# CITY OF ALBUQUERQUE

November 10, 2022

**Re: Dutch Bros**  
**2501 Juan Tabo NE**  
**Traffic Circulation Layout**  
Engineer's Stamp 10-24-22 (H21-D004A)

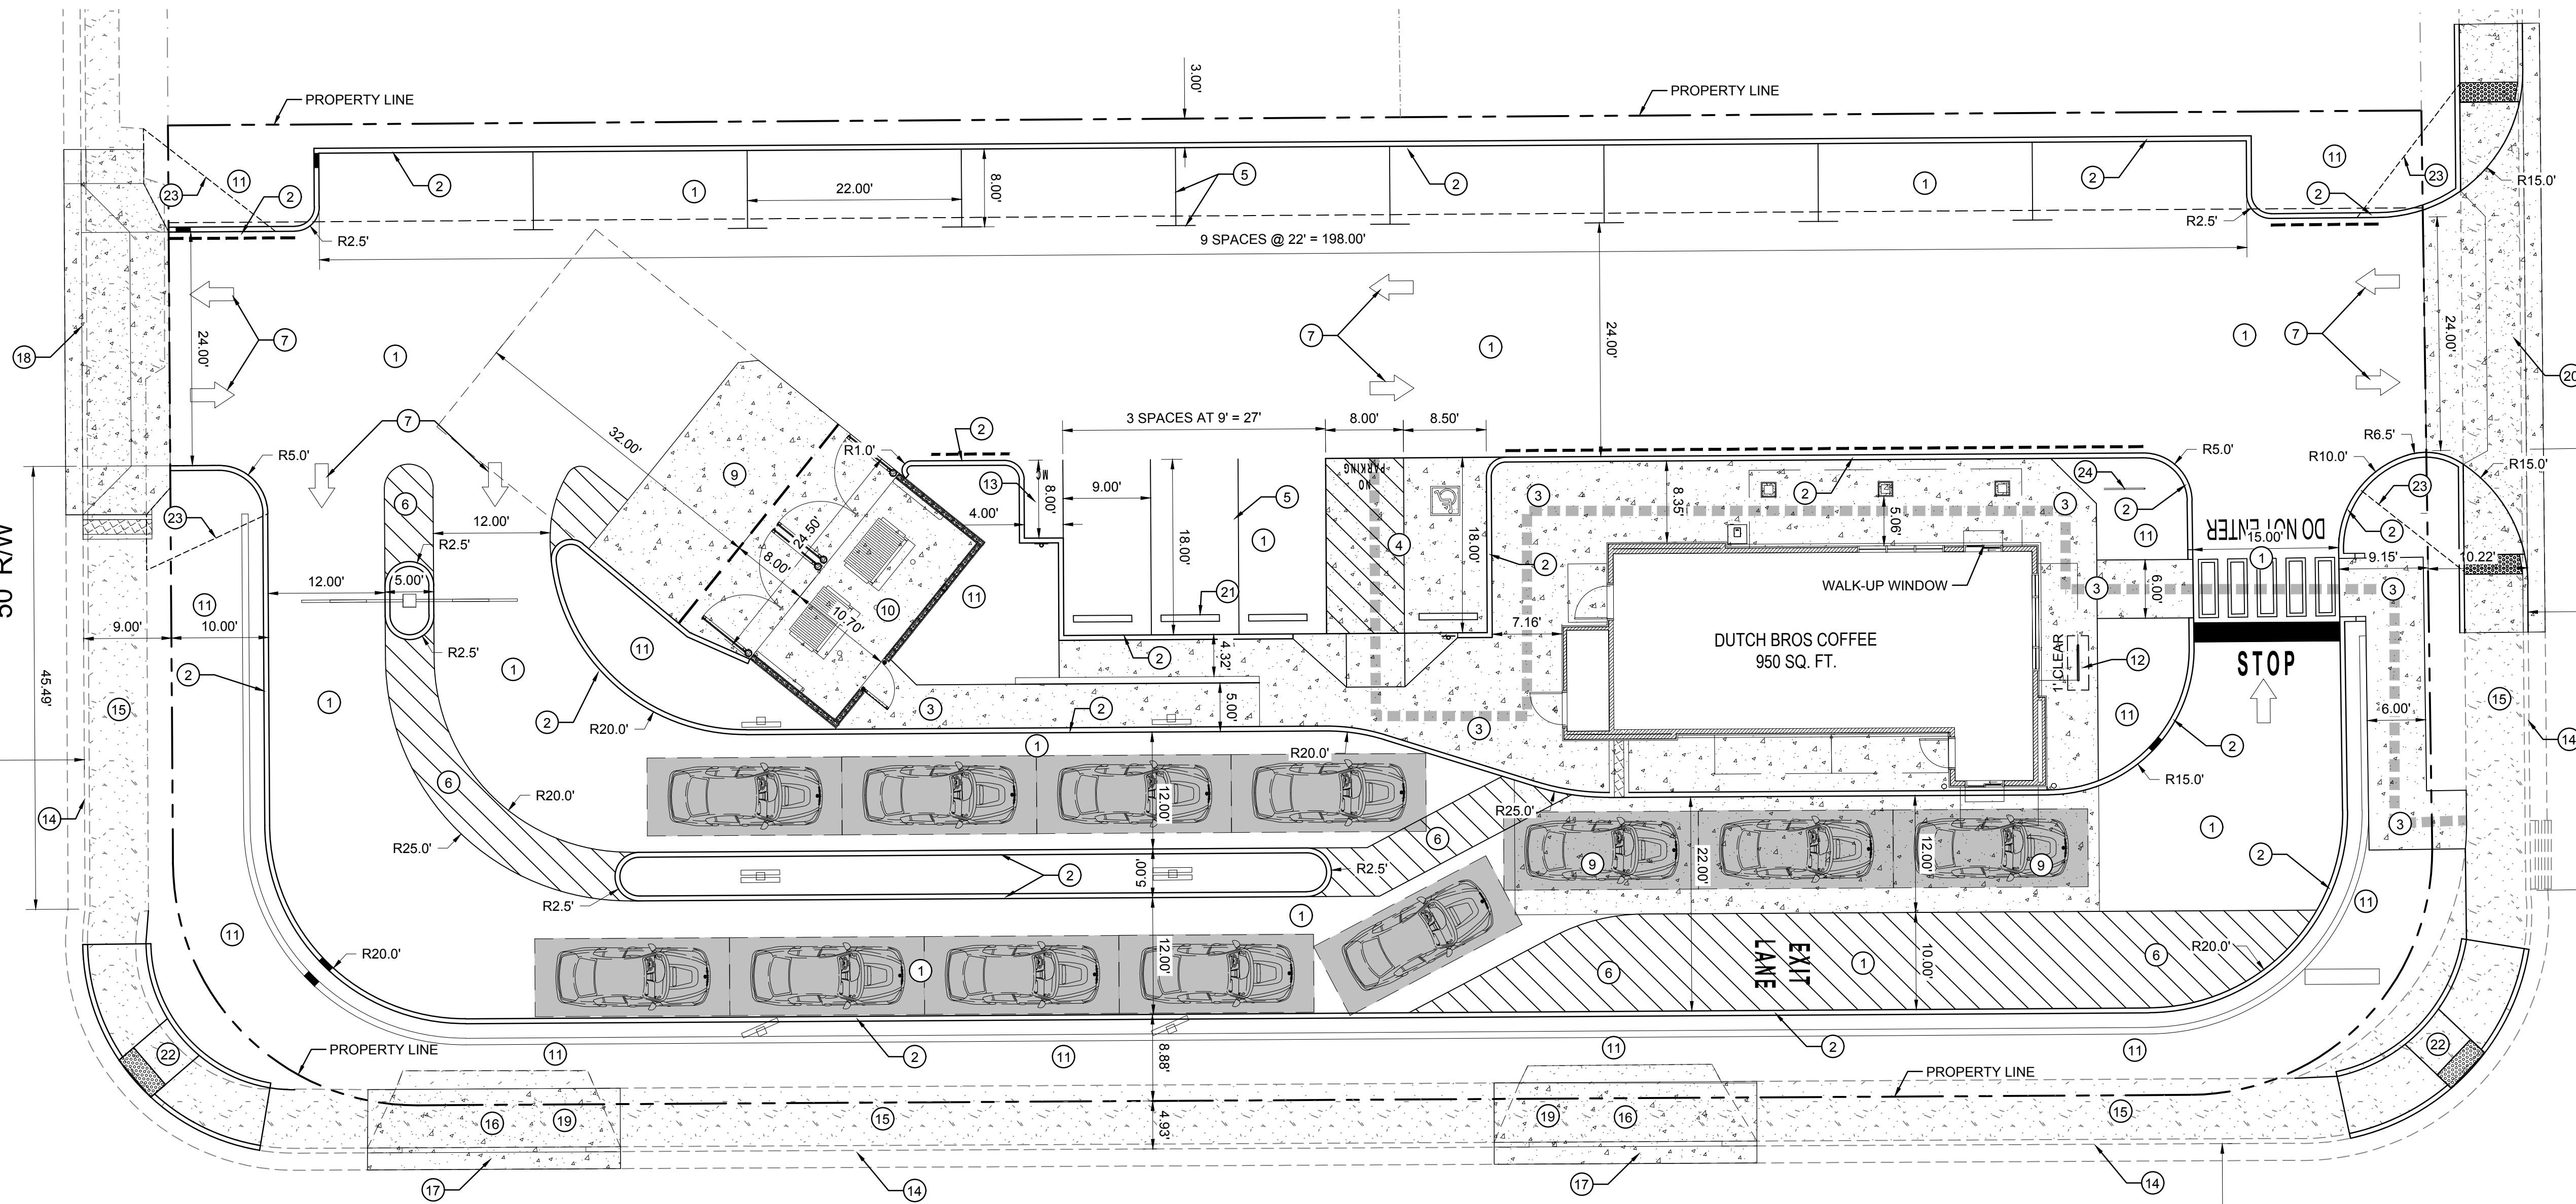
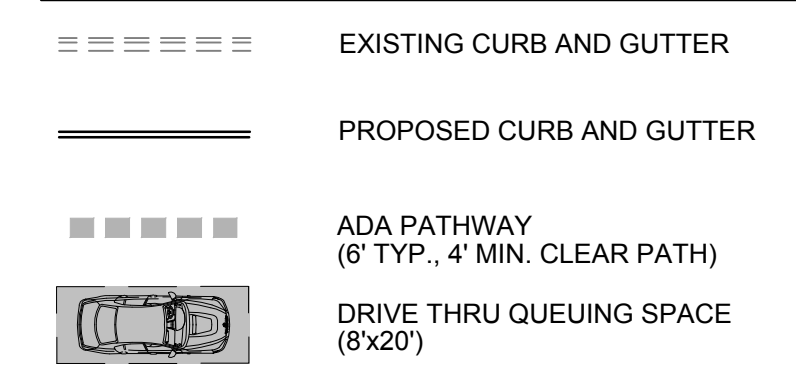
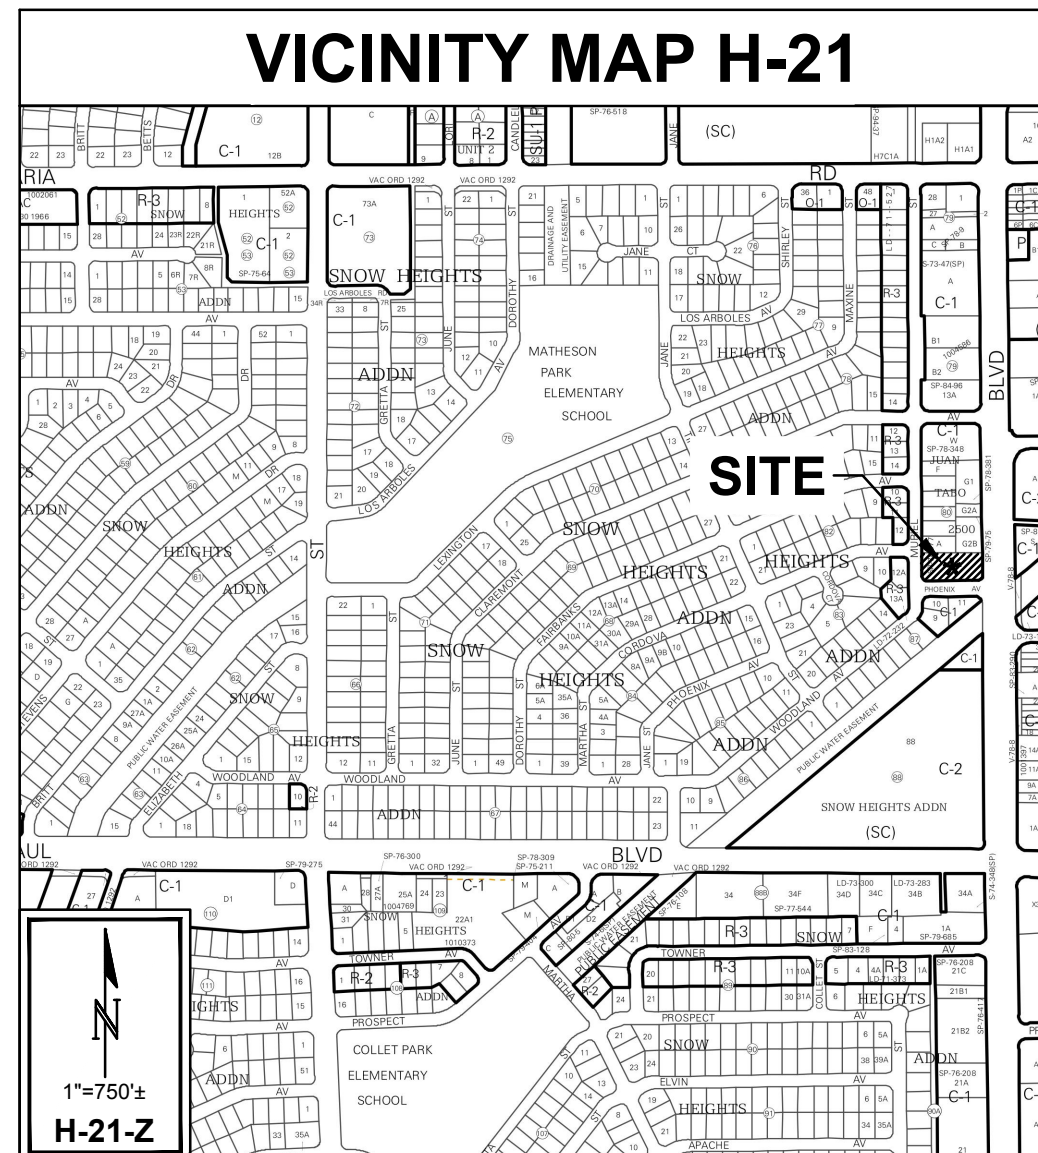
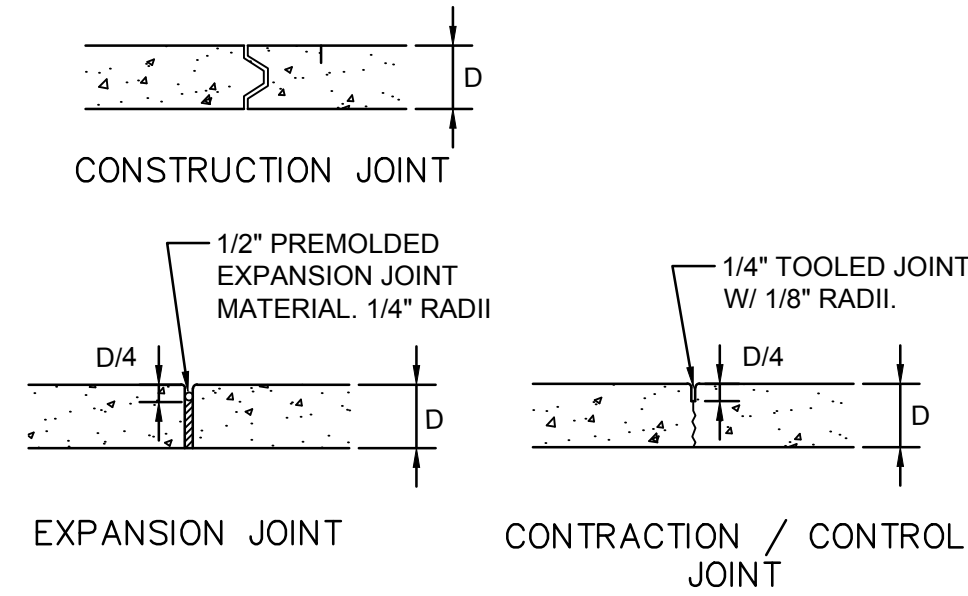
1. Please show a vicinity map showing the location of the development in relation to streets and well known landmarks.
2. Identify the right of way width, medians, curb cuts, and street widths on Juan Tabo Blvd, Phoenix Ave. and Muriel St. NE.

3. Per the DPM Table 7.4.46, Driveway access off Juan Tabo should be 150 ft. away from the intersection of Juan Tabo and Phoenix. Please clearly show this dimension on the site plan.

4. List radii for curves for driveway access off Juan Tabo; for passenger vehicles. Radius for delivery trucks, fire trucks, etc. is 25 ft. or larger.
5. Minimum throat length for this site should be 50 ft. please show this dimension on the site plan.

6. Minimum width for the ADA parking space is 8.5 ft.
7. Driveway access off Muriel should be built as a curb return design (per COA std dwg 2426) and provide the radius.

8. ADA curb ramp at the corner of Juan Tabo Blvd. and Phoenix Ave. must be updated to current standards and have truncated domes installed.
9. ADA curb ramp at the corner of Phoenix Ave. and Muriel St. must be updated to current standards and have truncated domes installed.

10. Please show 12 cars are stacking in the drive-thru lanes on the site plan.
11. All bicycle racks shall be designed according to the following guidelines:

15. Per the IDO, a 6 ft. wide ADA accessible pedestrian pathway is required from the public sidewalk to the building entrances. Please clearly show this pathway and provide details.

16. Per DPM, a 6 ft. wide ADA accessible pedestrian pathway is required from the ADA parking stall access aisles to the building entrances. Please clearly show this pathway and provide details.

- PO Box 1293
17. Refuse vehicle maneuvering shall be contained on-site. The refuse vehicle shall not back into the public right of way. provide a copy of refuse approval.

- Albuquerque
18. Provide a copy of Fire Marshal approval.
  19. Please provide "One Way" and "Do Not Enter" signage. And provide face signs details.
  20. Please provide a sight distance exhibit

- NM 87103
21. Show the clear sight triangle and add the following note to the plan: "Landscaping and signage will not interfere with clear sight requirements. Therefore, signs, walls, trees, and shrubbery between 3 and 8 feet tall (as measured from the gutter pan) will not be acceptable in the clear sight triangle.
